Please ask for: Ms Iqraa Malik
Email: iqraa.malik@terraquest.co.uk
Telephone: 01212341390
Our Ref: BN/60/21/HH
Your Ref:
Date: 17th May 2021

Application for Planning Permission for Works or Extension to a Dwelling

Development: Single storey Ground floor extension
Subject to planning approval because PDR removed.
Location: Rosemary Cottage 64a Downview Road Barnham PO22 0EE

Site Plan
0m 5m 10m 15m 20m
1:500 Scale bar

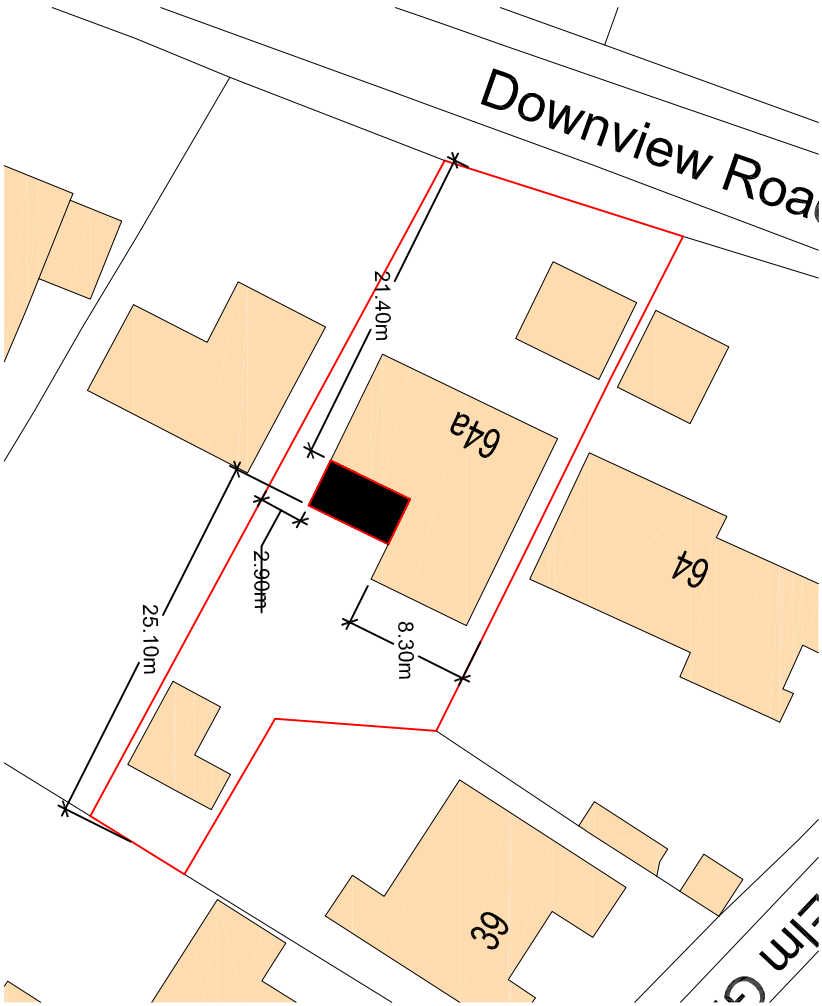
Dimensions: You are required to include dimensions on the block plan from the proposed extension to all site boundaries.

Drawing Title:
Existing Plan and Elevations

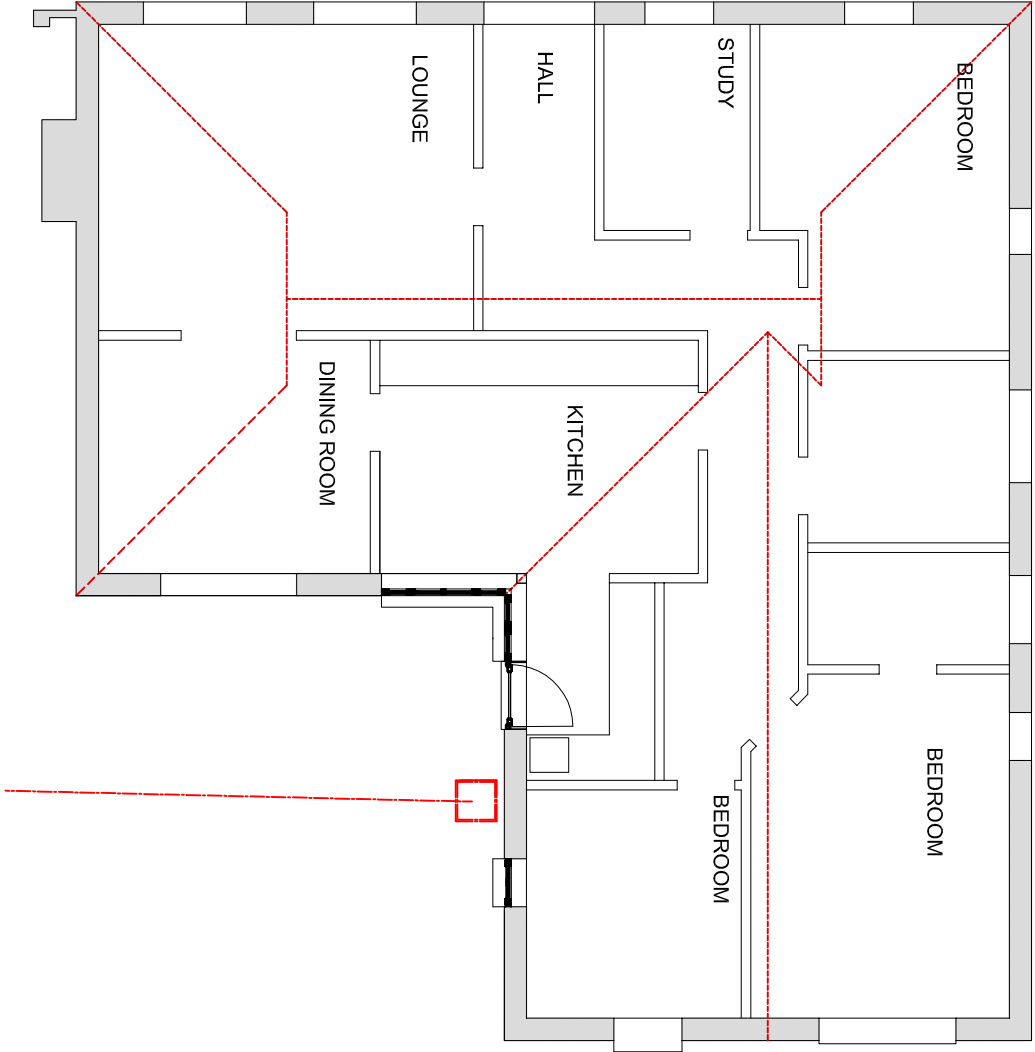
Room Labels: You are required to include room labels on all plans. Please amend
